**Lancashire
Constabulary**
police and communities together

28th August 2013

Planning Application 3/2013/0737 - Outline Application for up to 62 dwellings at Hanson Garden Centre, Whalley

Drawing file: planx_downloads / 13_0737_New_Site_plan_23_Jan_14.pdf

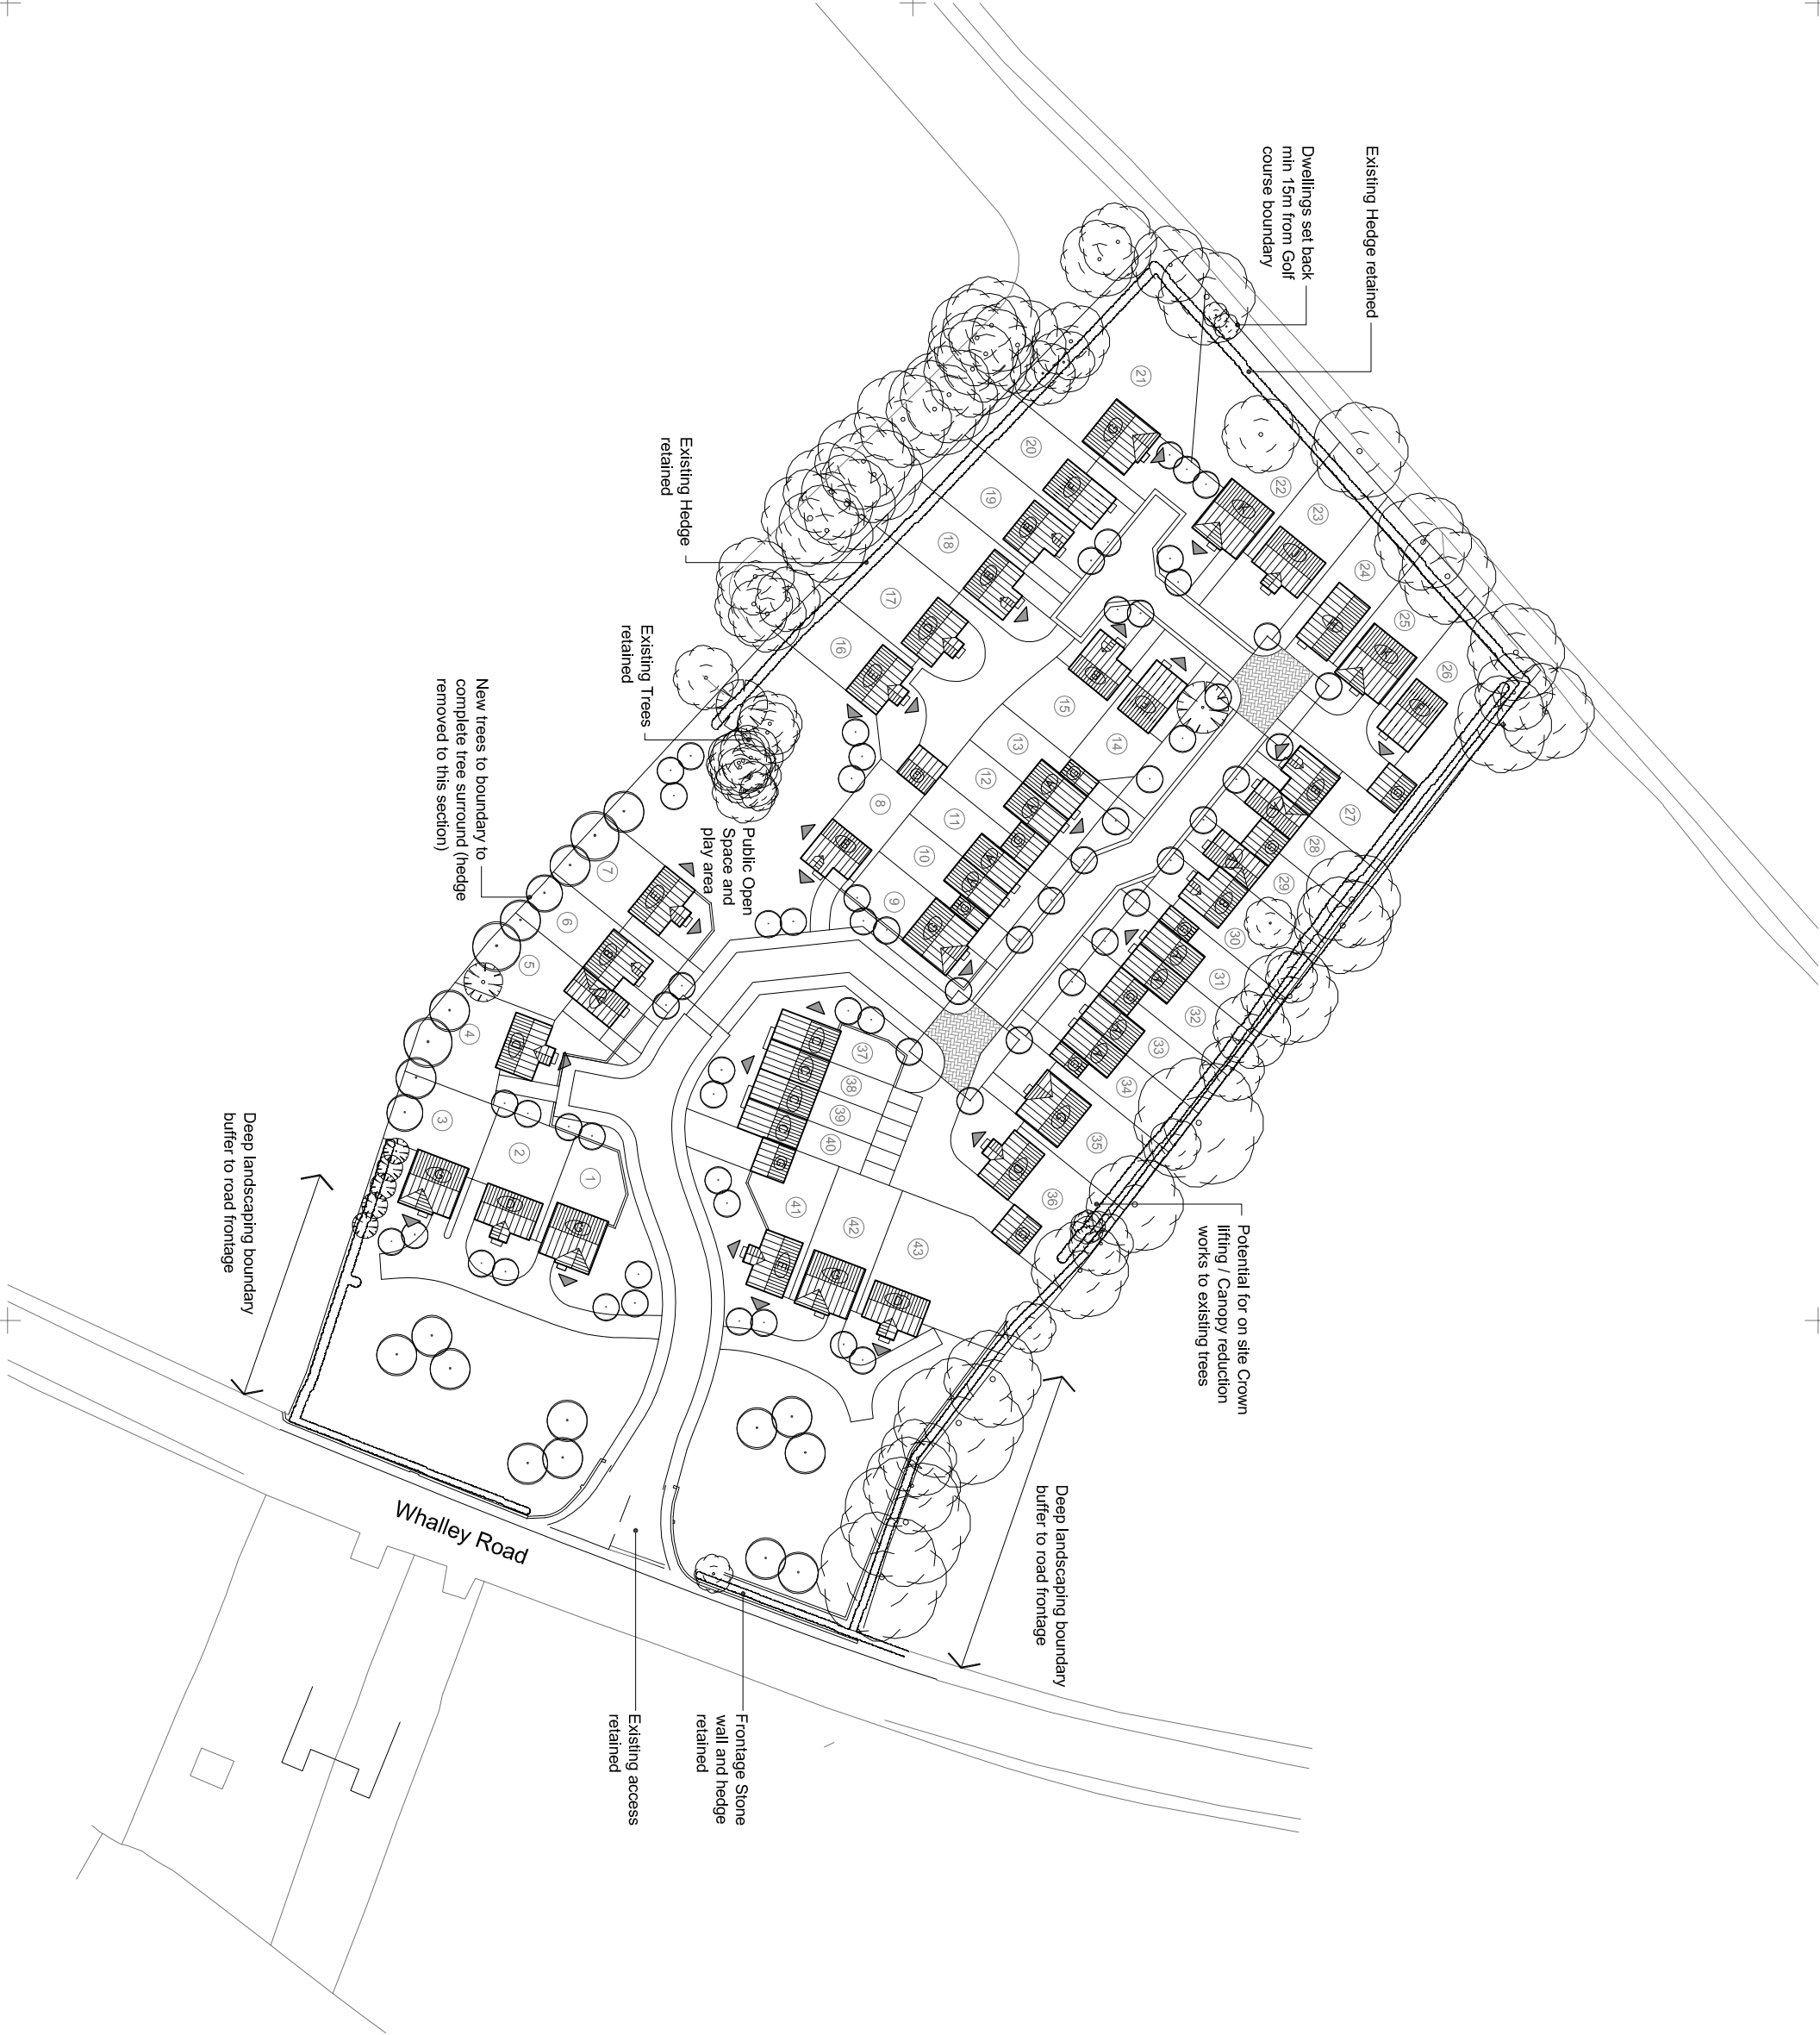
- Secured By Design promotes the use of cul de sacs as they reduce the pedestrian traffic through an area to residents and legitimate visitors. Residents are more likely to recognise each other and regular visitors, therefore an intruder is more likely to stand out where they would blend in, in a through route. This can deter the intruder as they are at a greater risk of detection. This layout makes good use of this design.

- Different orientation of dwellings promotes natural surveillance throughout the development, again making it less appealing to an intruder and reducing the likelihood of anti-social behaviour becoming a problem. This layout has varying orientation of the dwellings which helps to enhance natural surveillance around the dwellings.

- In curtilage parking reduces the opportunity for auto-crime. This layout indicates in-curtilage parking throughout the development. Should this change, and parking courts are introduced, they should be kept to a minimum and where absolutely necessary, they should be well overlooked by the properties they serve and lit. Parking bays should be clearly marked with the property number they relate to reduce the likelihood of neighbour disputes arising over parking spaces.

- The boundary treatment around the rear gardens should be a minimum of 1.8m to deter intruders intending to commit theft and burglary.
- Access to the rear garden from the front should be restricted by a 1.8m lockable (from the inside) gate.

- Defensible space is provided to the front of all properties, which reduces the likelihood of nuisance/anti-social behaviour being caused to the occupants as provides a 'buffer' between public and private space.

- Any garages should not have windows as they provide a view of valuables stored inside and are a weak point for intrusion.
- Defensible space should always be provided for exposed gables which abut a pavement, parking area etc. This can be achieved by railings or defensive planting.

- Blank gables with no windows should be avoided as they reduce the opportunity for natural surveillance.
